From: Paul Cann
Sent: 27 September 2017 16:18
To: Planning.Responses
Subject: RE: Planning Consultation on EG/72/17/DOC

APPLICATION NO: EG/72/17/DOC

Registered: 31-AUG-17
Site Address: 2 Critchmere Road Eastergate PO20 3XA

Description of Works: Application for approval of matters reserved by condition imposed under EG/38/17/HH relating to condition 4 for surface water drainage.

Ground Floor Plan
Surface Water Drainage

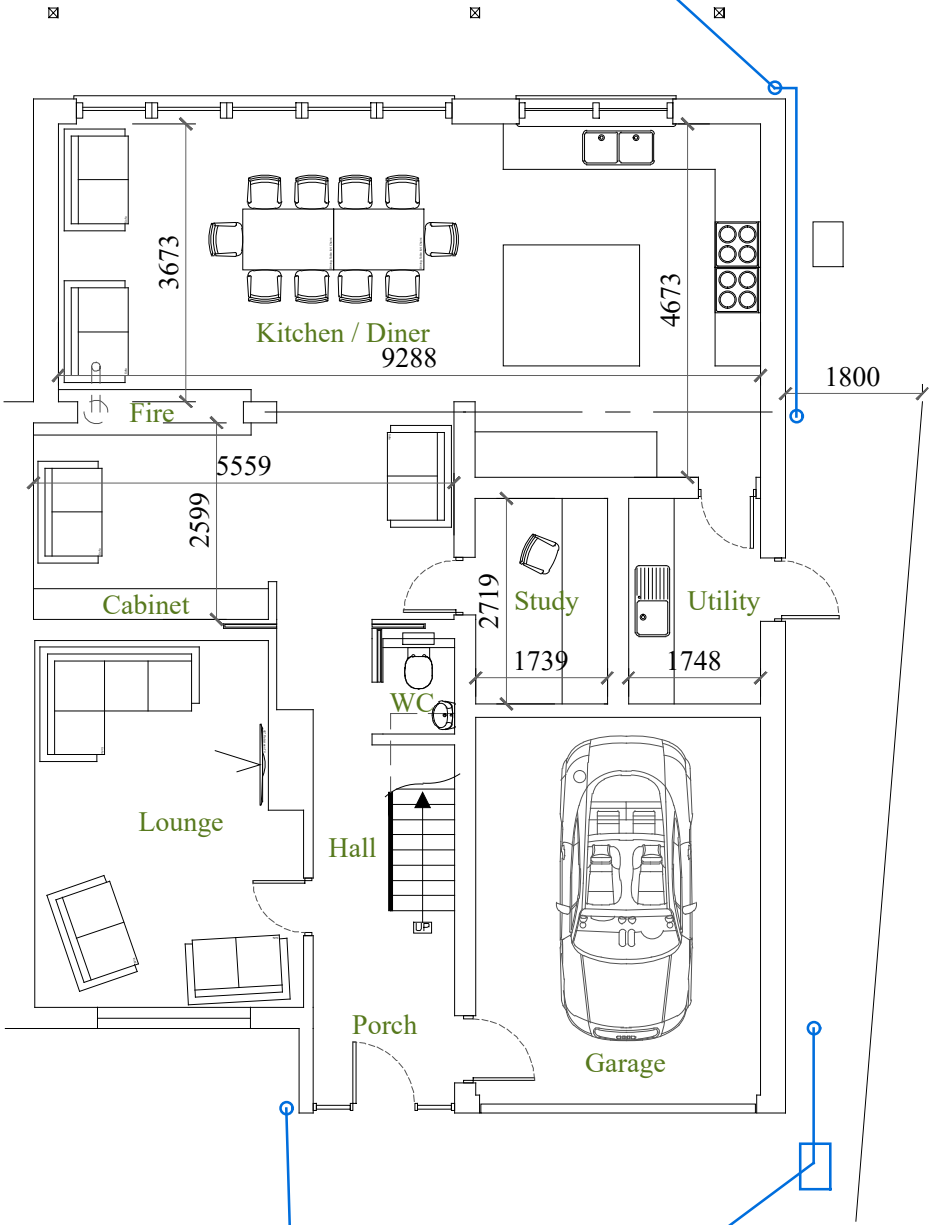
The applicant does not appear to have investigated winter groundwater levels or undertaken winter percolation testing at an agreed depth/location. If soakaways prove feasible, then new soakage structures will be required to serve the new extensions. Discharge into existing soakaways will not be permitted.

The detailed design will need to be supported by hydraulic calculations/construction details.

Therefore, at this time it is not possible to consider the application further and the condition cannot be discharged.
